Cliffe Lane, Gomersal

Highway Response Report

PROJECT TITLE: Cliffe Lane, Gomersal
REPORT TITLE: Highway Response Report
PROJECT REFERENCE: 152130
DOCUMENT NUMBER: 003
ISSUE NUMBER: 01
DATE: March 2024

HOUSE TYPES F, G & H

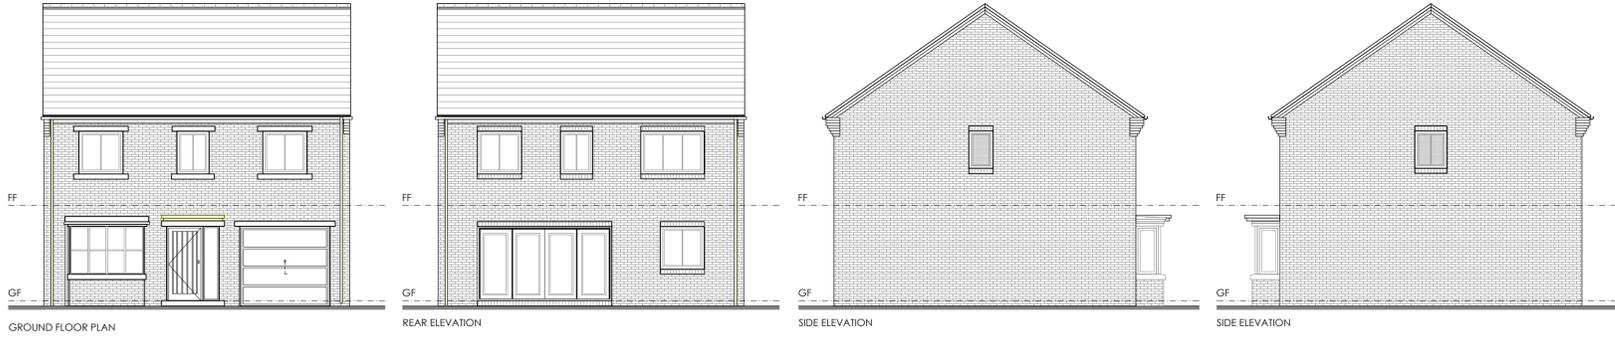
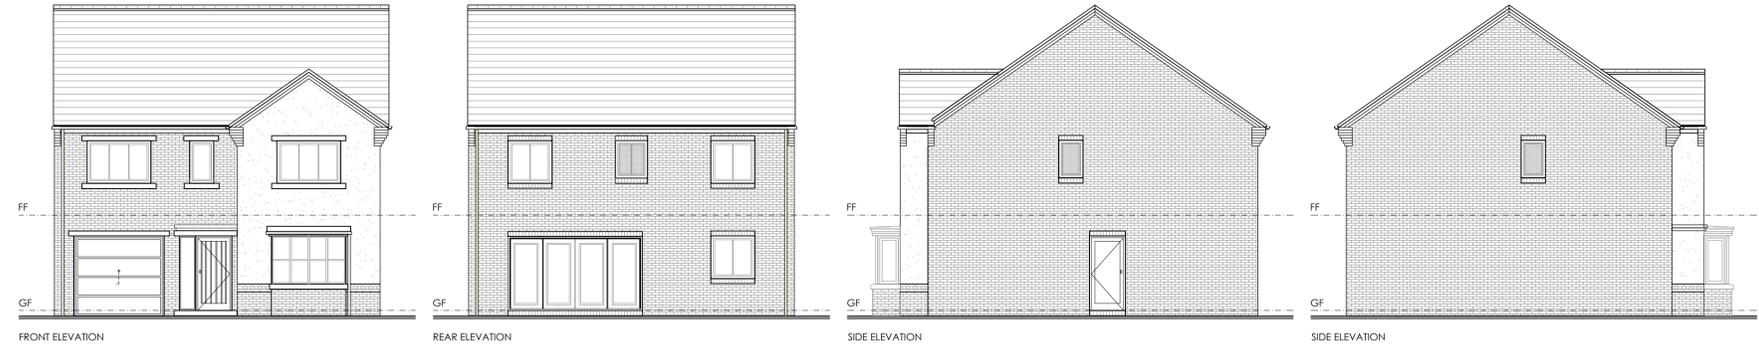
The applicants should be asked to confirm the internal dimensions of the integral garages. 6m x 3m is required as a minimum to be counted as a parking space.

All internal garages are a minimum of 6m x 3m.

HOUSE TYPE M3, 3 STOREY SPLIT
SEMI, 3BED, 5PERSON = PLOTS
53, 54, 55, 56, 65, 66, 77, 78, 86 & 87

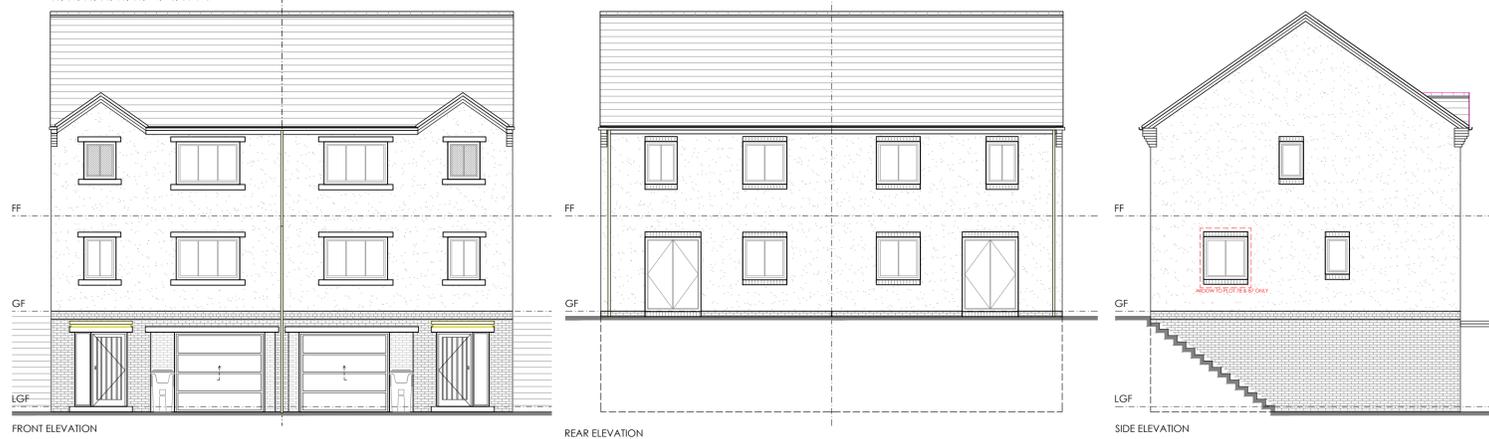
The handwritten annotations of some the house types are difficult to read particularly M3(3 bed with garage) and N3(4 bed with garage). Can the applicants confirm the M3 house types have 2 off-street parking spaces and N3 have 3.

Please refer to LOROC Architects site plans and housing schedule.
